M54 to M6 Link Road

**8.8 P(A) Draft Statement of Common
Ground with Environment Agency**

Version	Date	Status of Version
4 (P06)	8 January 2021	Issue to the ExA at Deadline 4

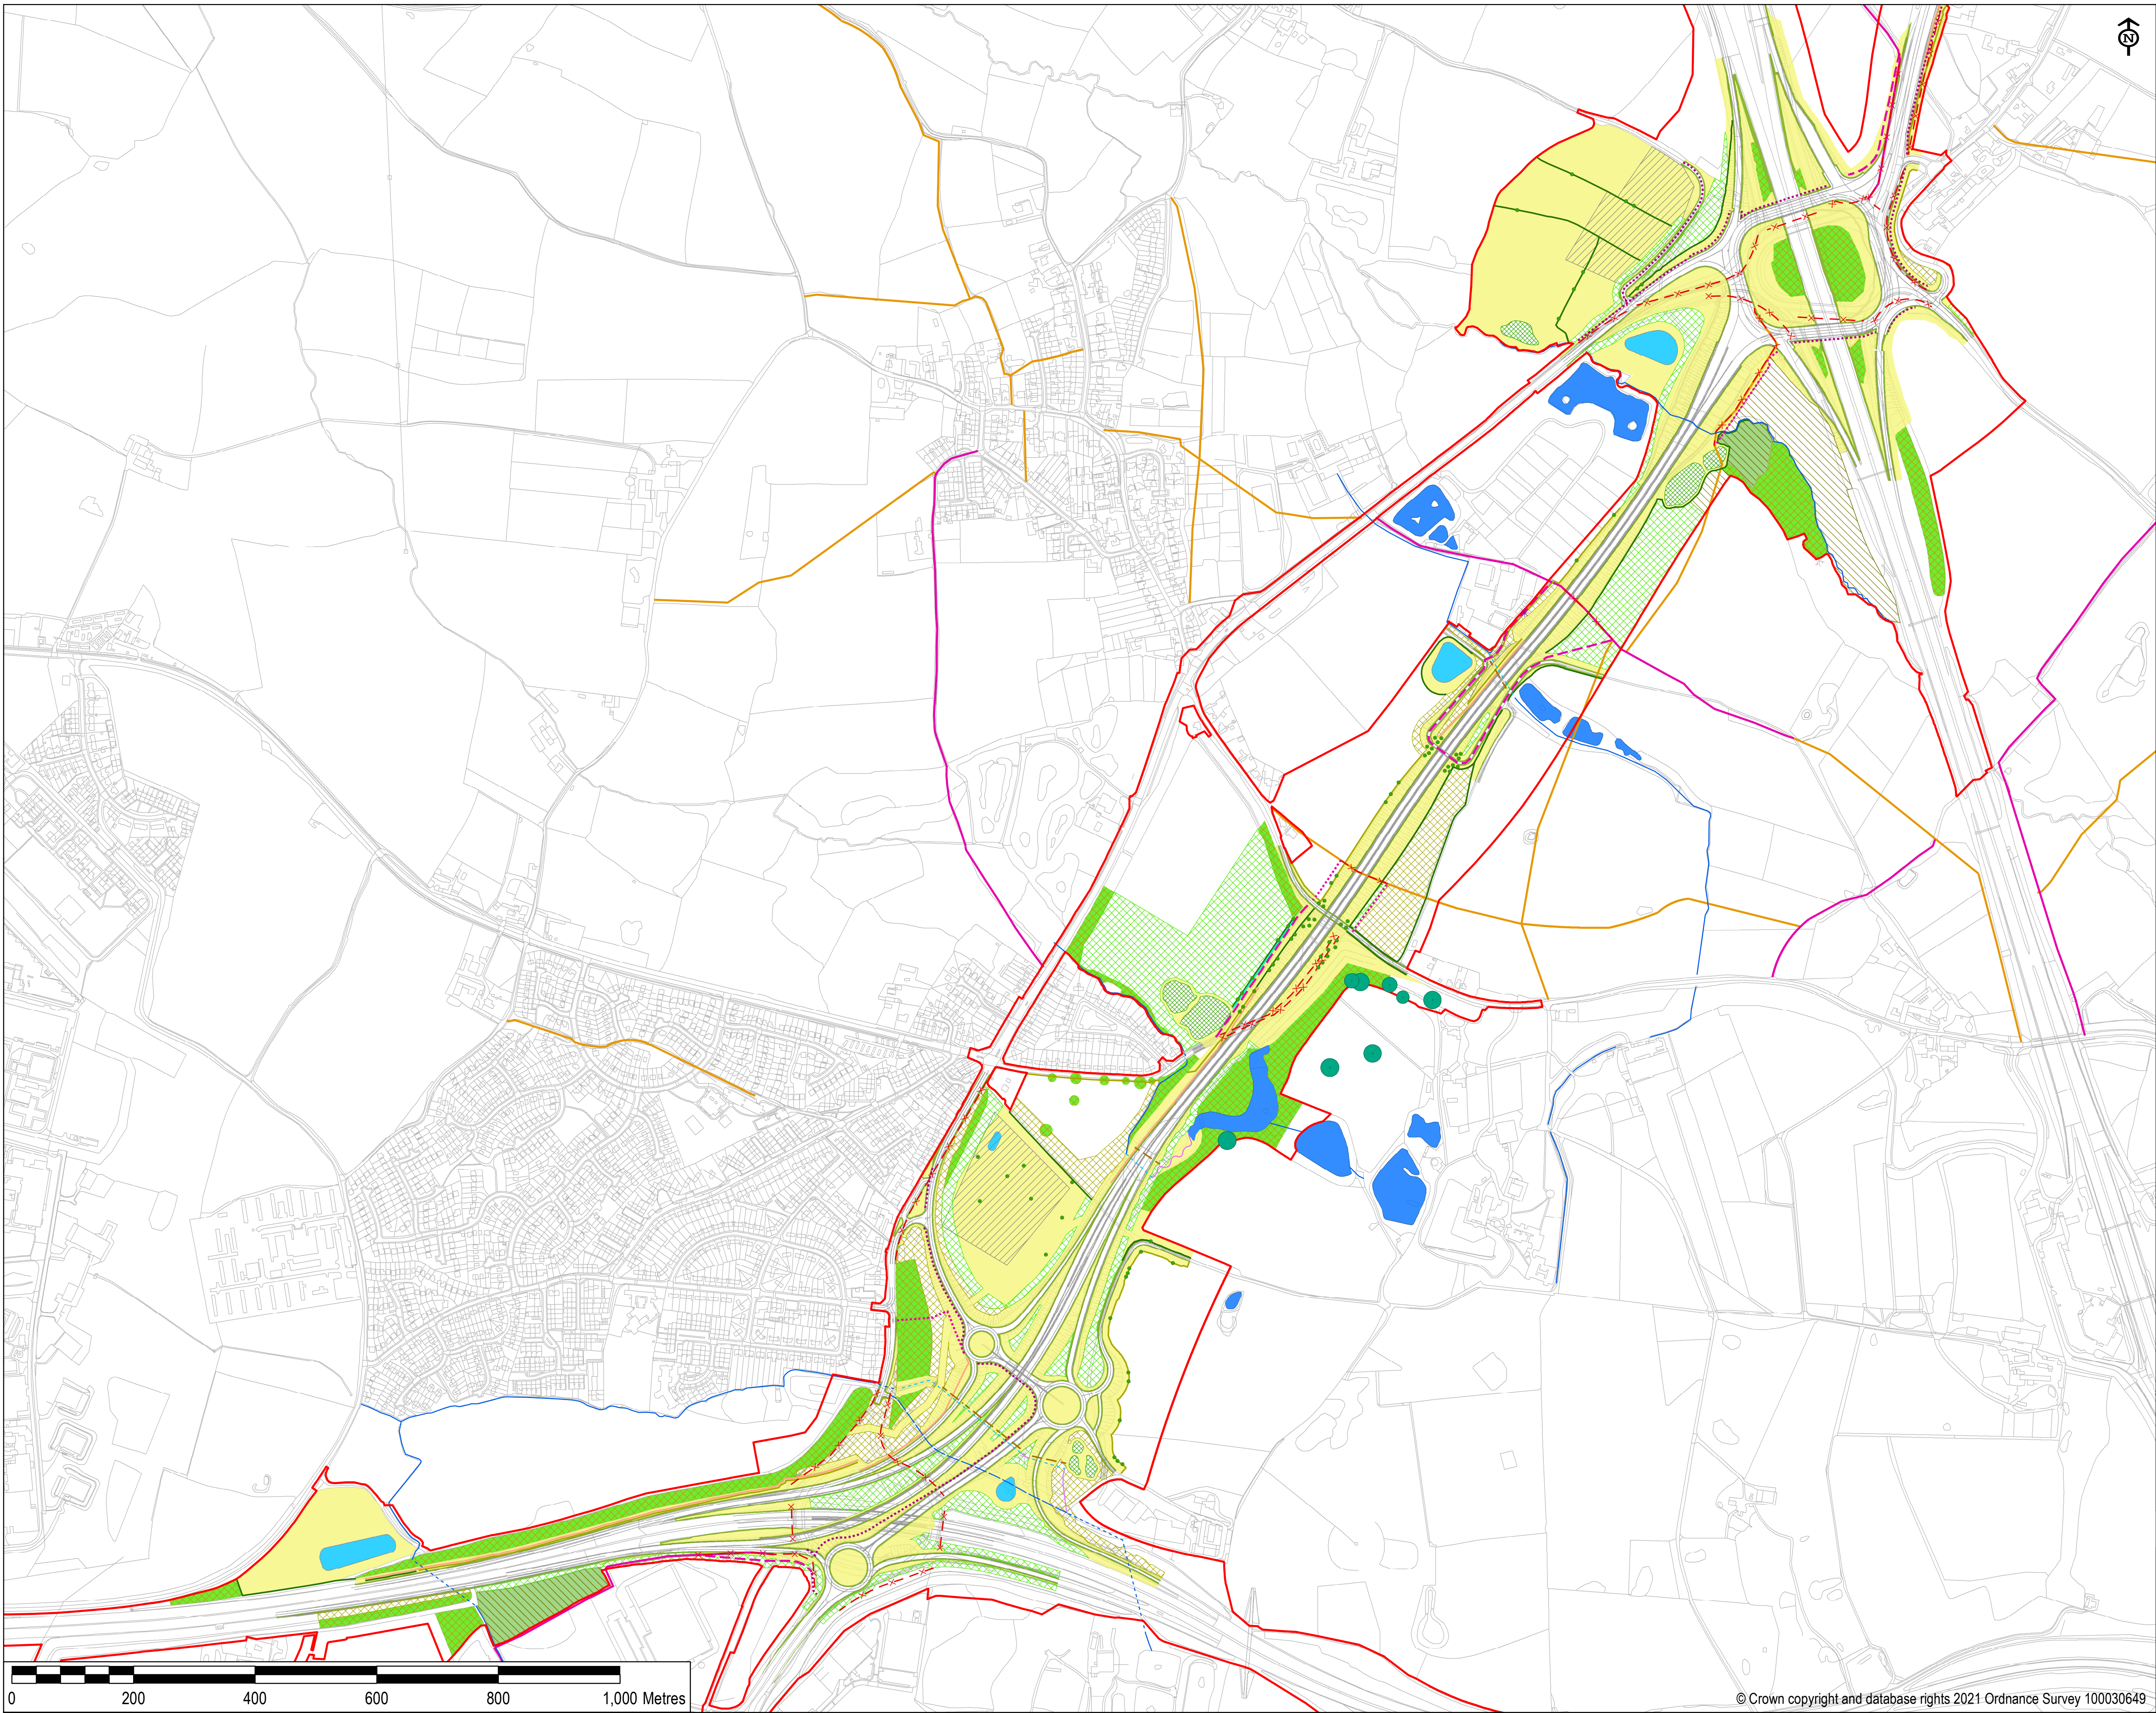
ES Chapter	Paragraph Reference	Sub-section	Environment Agency Comment	Highways England Response	Status	Agreement likely?	
						APP? ¹	IP?
				<p>13.2 Drainage Strategy [APP-201/6.3], Figure 2.1 of the ES Draft Environmental Masterplan Overview [APP-057/6.2], and Outline Drainage Works [AS-072/2.11] (see Sheets 3-5). However, to support the interpretation of the environmental commitments made and to help illustrate what the proposals aspire to provide, Highways England has prepared an additional figure, Figure 1: Proposed Watercourse which is appended to this SoCG. Although the detailed design of new ditchcourses, channel diversions and realignments will be done during the detailed design stage, and will be site specific, (a figure will be produced and provided to support this ongoing discussion), to illustrate project aspiration in terms of ditchcourse and existing channel diversion/realignment design.</p> <p>Following the result of 2020 great crested newt (GCN) surveys these mitigation measures have been reviewed and amended as appropriate. The surveys confirmed the likely absence of GCN in those ponds which would be lost as a result of the Scheme. As no ponds known to support GCN would be lost the replacement of pond habitat is only required at an</p>
